From: Katie Kurek [REDACTED] **On Behalf Of** CCD Planning Consultations
Sent: 26 September 2017 13:10
To: Planning.Responses
Cc: David X Edwards
Subject: RE: Planning Consultation on: BR/229/17/PL

**WEST SUSSEX COUNTY COUNCIL
PLANNING SERVICES CONSULTATION**

SUBJECT: BR/229/17/PL - Erection of 4 No. dwellings, 1 No. detached garage, parking & alterations to existing access & driveway (resubmission following BR/200/16/PL).

Land to rear of 41 - 47, Pevensey Road, Bognor Regis, West Sussex, PO21 5NY

DRAWING TITLE	
Block & Location Plans and Site Section	
DATE	SCALE
Feb 18	1:200 @ A1
JOB NO.	DRAWING NO.
1615	2.13
	CHECKED BY
	REVISION
	DRAWN BY
	GIM

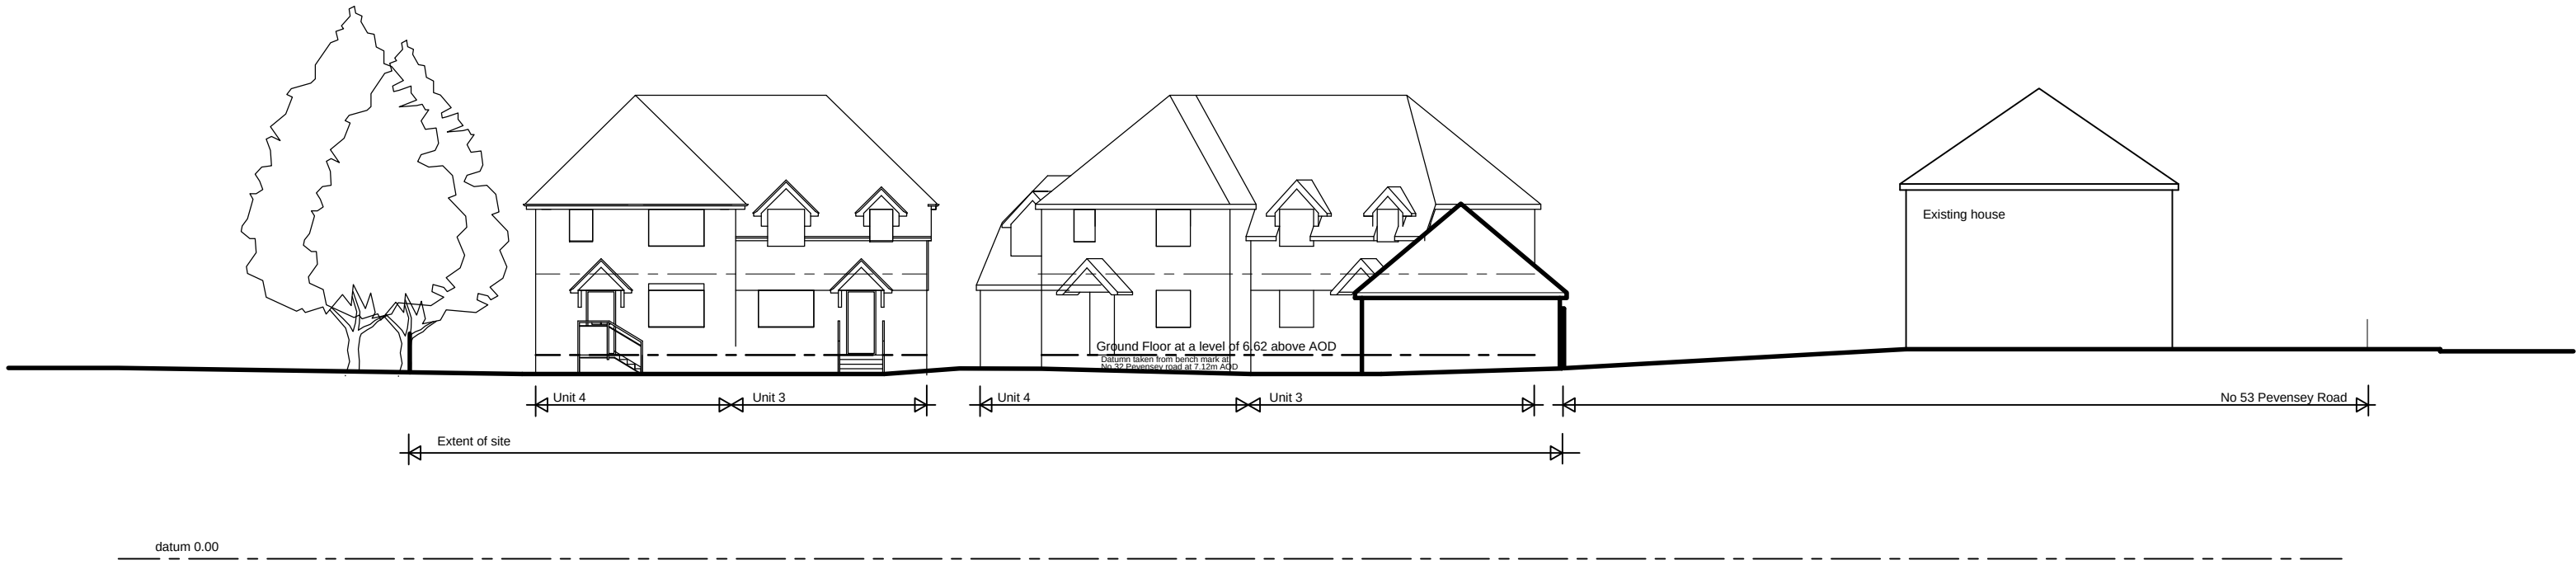
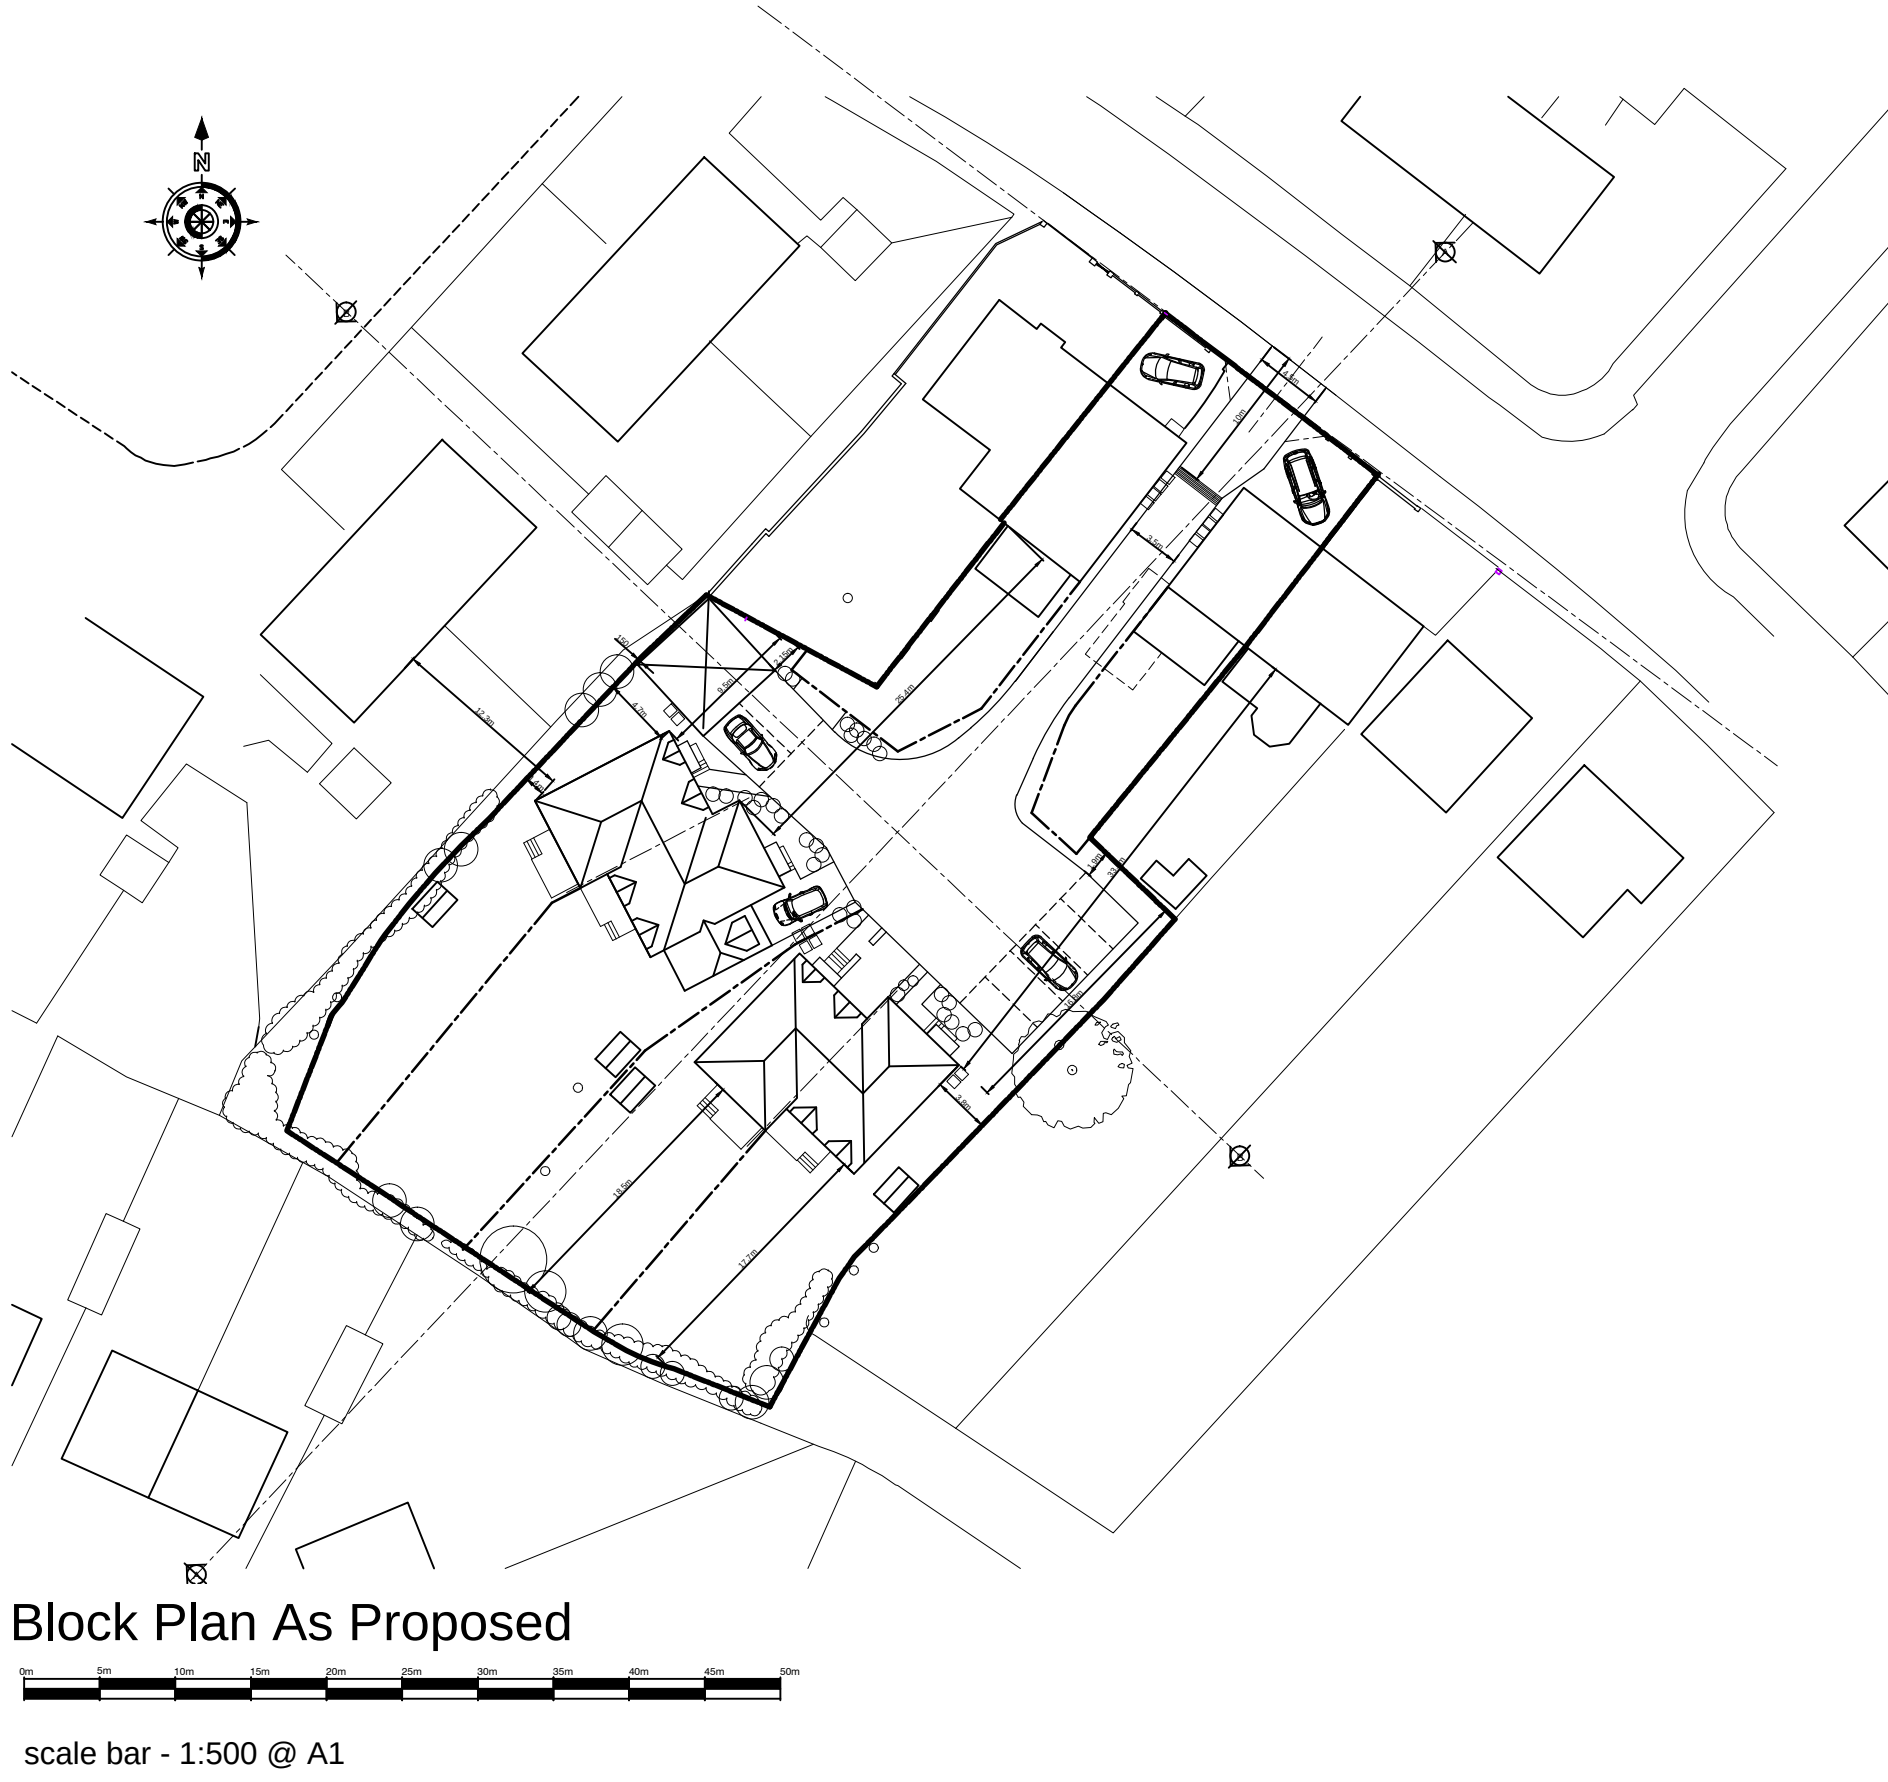
As per previous comments the existing access will be utilised with the existing dropped kerb providing a 4.5m wide access into the site. The existing dropped kerb will also facilitate access to a single off street car parking space per

existing dwelling (no. 43 and 45). As previously, the access road will narrow to 3.5m however, there is space available for a car to wait at the entrance in the instance of a car exiting the site at the same time. We would advise that an Access Protection Line is included across the existing dropped kerb to deter parking across this existing access point.

The parking arrangements and layout has been altered. A single detached garage will provide a single space for no. 45 and a space fronting this. The remaining detached garage space and space fronting this will be allocated to Plot 1. Plot 2 has an integral garage. The internal dimensions of this garage do not meet required to be counted as a parking space. We would advise this be widened to 3m so that this space and hardstanding fronting will count as two allocated spaces for plot 2. Plot 3 is served by one external car parking space and will have an allocated space within the remaining forecourt spaces. Two of these forecourt spaces will also be allocated to plot 4. The two remaining forecourt spaces should be kept as unallocated parking for the development as a whole. On the basis of the allocated spaces described above a total parking demand of nine spaces is envisioned for the development. With ten total spaces the LHA consider that parking quantity is suitable for the development's needs. Sufficient space is available within the site to allow cars to turn and exit on to Pevensy Road in a forward gear.

Although we would advise that plot 2 garage be widened internally the LHA are satisfied that sufficient parking provision is available on site without this being counted toward allocated parking provision and therefore do not raise any concerns to parking and turning arrangements demonstrated.

The refuse collection will be from the roadside as per existing dwellings. A point for collection has been shown approximately 10m from the roadside meeting bin collection distances. These arrangements omit the need for a refuse collection vehicle to turn on site.

Swept path for a fire vehicle has been demonstrated accessing the site from the centre of the road – in case of on-street parking. Whilst on-street parking close to the junction with Firth Road may impinge on this swept path the LHA are satisfied with these arrangements from a highway safety point of view. The applicant should be aware that demonstration of fire safety measures may be required to meet building regulations, though this is not a material planning consideration.

No part of the development shall be first occupied until pedestrian visibility splays of 2 metres by 2 metres have been provided either side of the site vehicular access onto Pevensy Road in accordance with the approved plan. These visibility splays shall thereafter be kept free of all obstructions over a height of 0.6 metre above adjoining carriageway level or as otherwise agreed.

No part of the development shall be first occupied until the vehicle parking and turning spaces have been constructed in accordance with the approved plan. These spaces shall thereafter be retained for their designated use.
